Rezoning Transportation Analysis

Petition Number: 2021-100

Revision Log:

Date	Description
8-20-2021	First Review (DBS)
9-22-2021	Second Review (BKB)
10-18-2021	Third Review (AO)
11-22-2021	Fourth Review (PDM)

CONCEPT
SITE PLAN

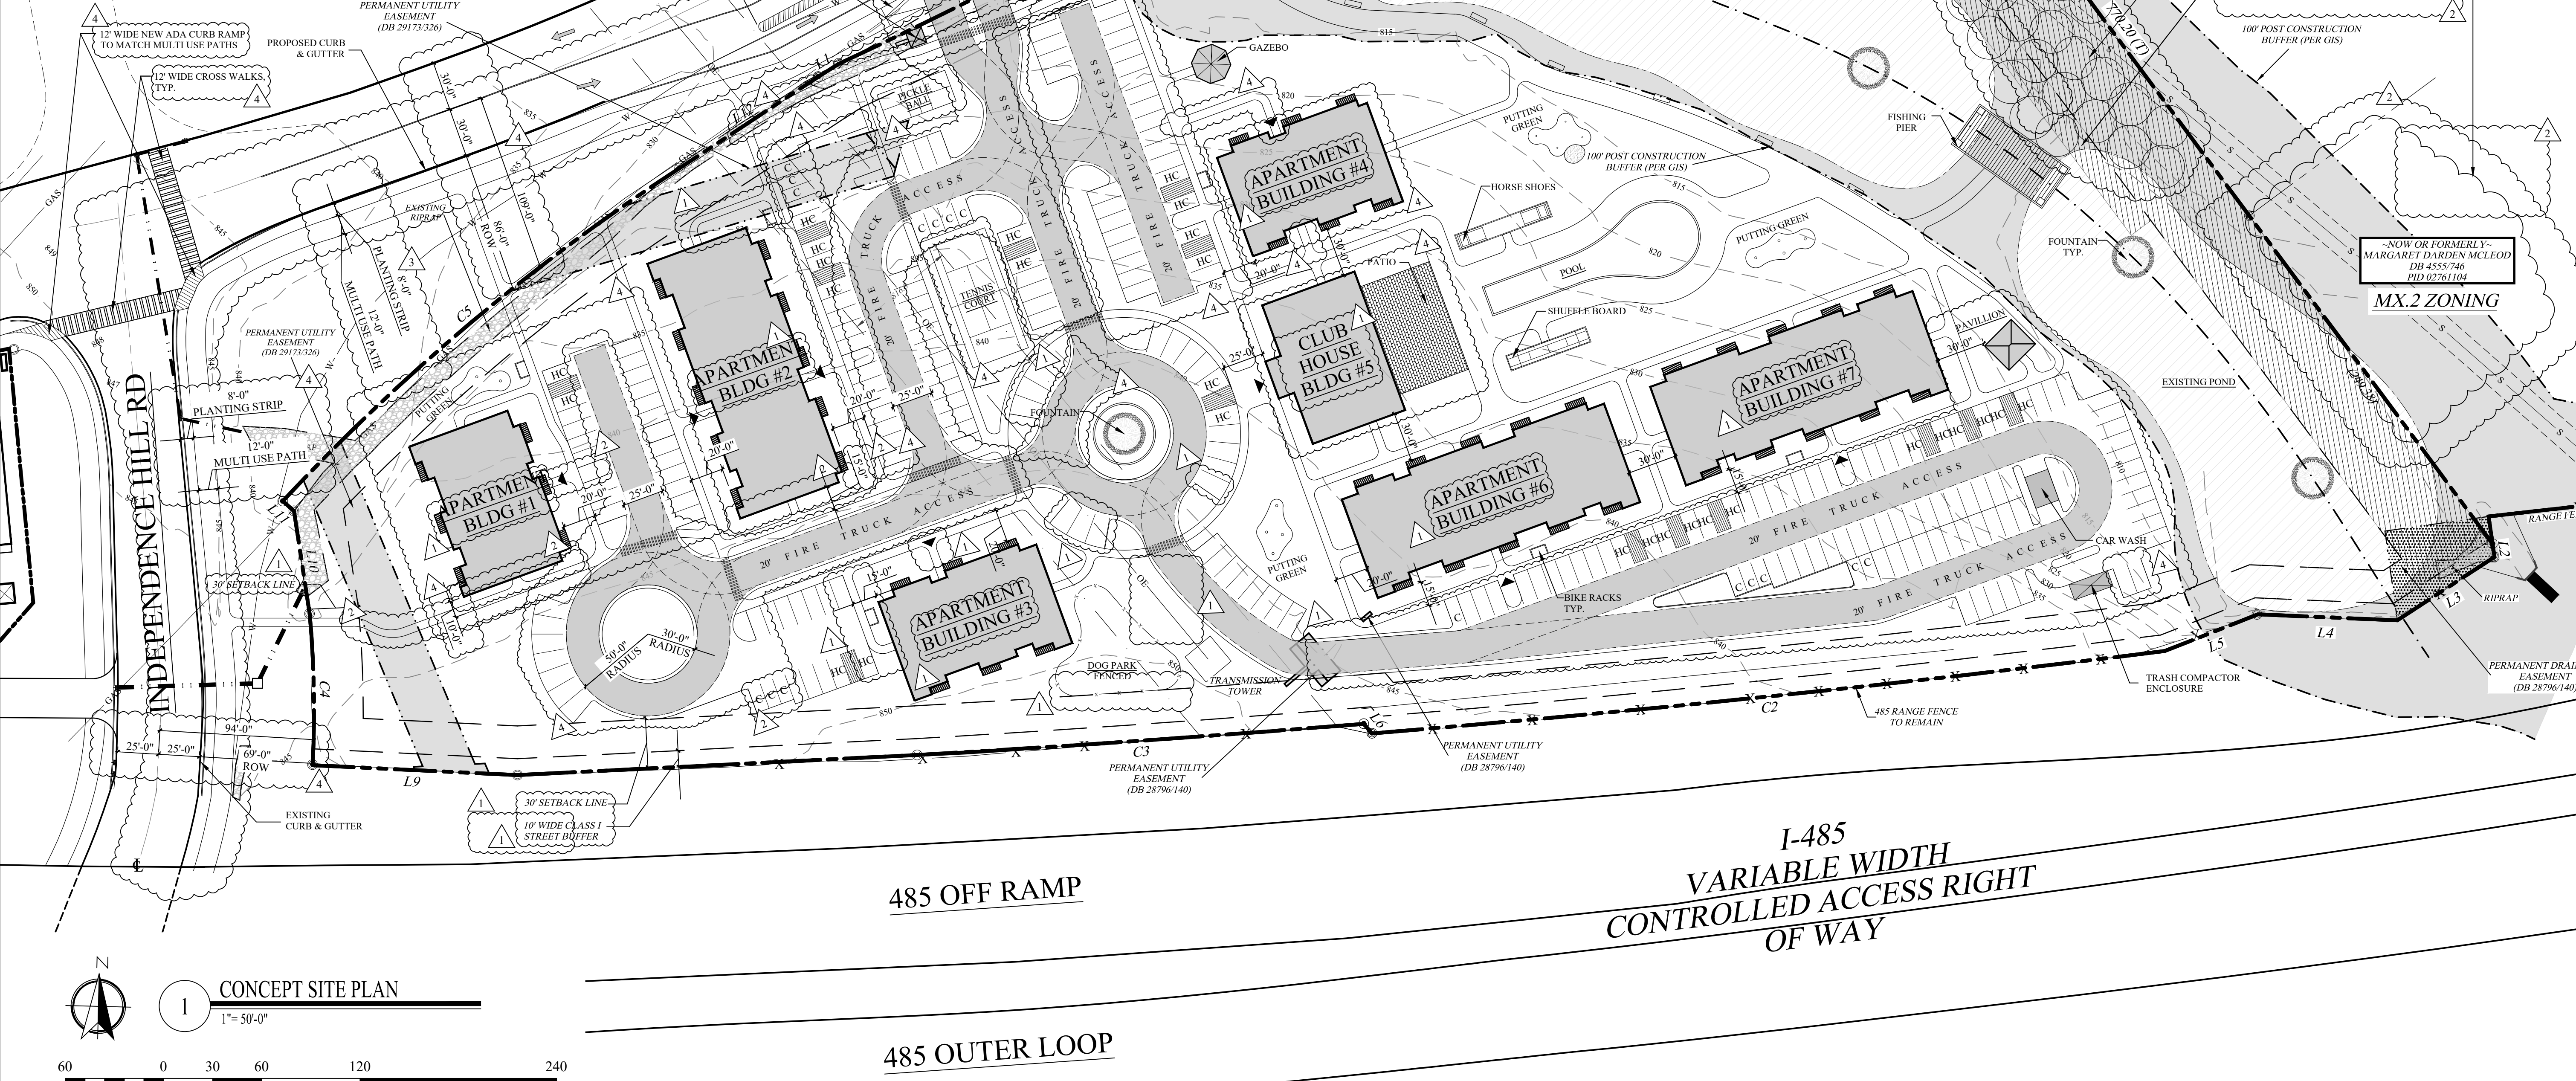
- Outstanding Comment from 9-22-21:** The curbline along Eastfield Road shall be shown at 30' from centerline to back of curb. Revise site plan to reflect this condition and label and dimension the right-of-way and curb and gutter from the Eastfield Road centerline.

Outstanding Comment from 11-22-21: Add labels/callouts for the ROW and the proposed curb and gutter. Dimension the ROW on Eastfield Road from the centerline.

- Outstanding Comment from 9-22-21:** Revise site plan and conditional notes to label and describe location of the existing curb location and right-of-way along Independence Hill Road. The site plan shall label and dimension the curb and right-of-way from the road centerline.

Clarifying Comment from 9-22-21: Current plan shows 6' back of curb sidewalk along Eastfield and Independence Hill Roads. Revise site plan and add conditional note to construct 8-foot planting strips and 12-foot multi-use paths on Eastfield and Independence Hill Road frontages. Two new curb ramps will be need to be constructed on the southeastern corner of Independence Hill Road and Eastfield Road at a width of 12' for each to match the MUP's. Add conditional note committing to construction and maintenance of these facilities.

Outstanding Comment from 11-22-21: Label and dimension MUP along Independence Hill Road. Add conditional note(s) committing to construction and maintenance the MUP facilities along Eastfield Road and Independence Hill Road. In addition, revise site plan to show additional ADA ramp to cross Eastfield Road on the southeastern corner of the Independence Hill Road and Eastfield Road intersection.

6. Revise site plan and add conditional notes showing access points off Eastfield Road and Independence Hill Road to be right in-right out only.
Clarifying Comment from 9-22-21: Per email dated 09-28-2021 from Wendy Taylor, a 100' RTL and 150' LTL were added for the access point off Eastfield Road. Show existing striping on Eastfield Road and show the existing LTL taper shortened from Eastfield Road to Independence Hill Road and create a striped section separating the two LTLs.
Outstanding Comment from 11-22-21: Add conditional note(s) committing to the 100' RTL and 150' LTL.
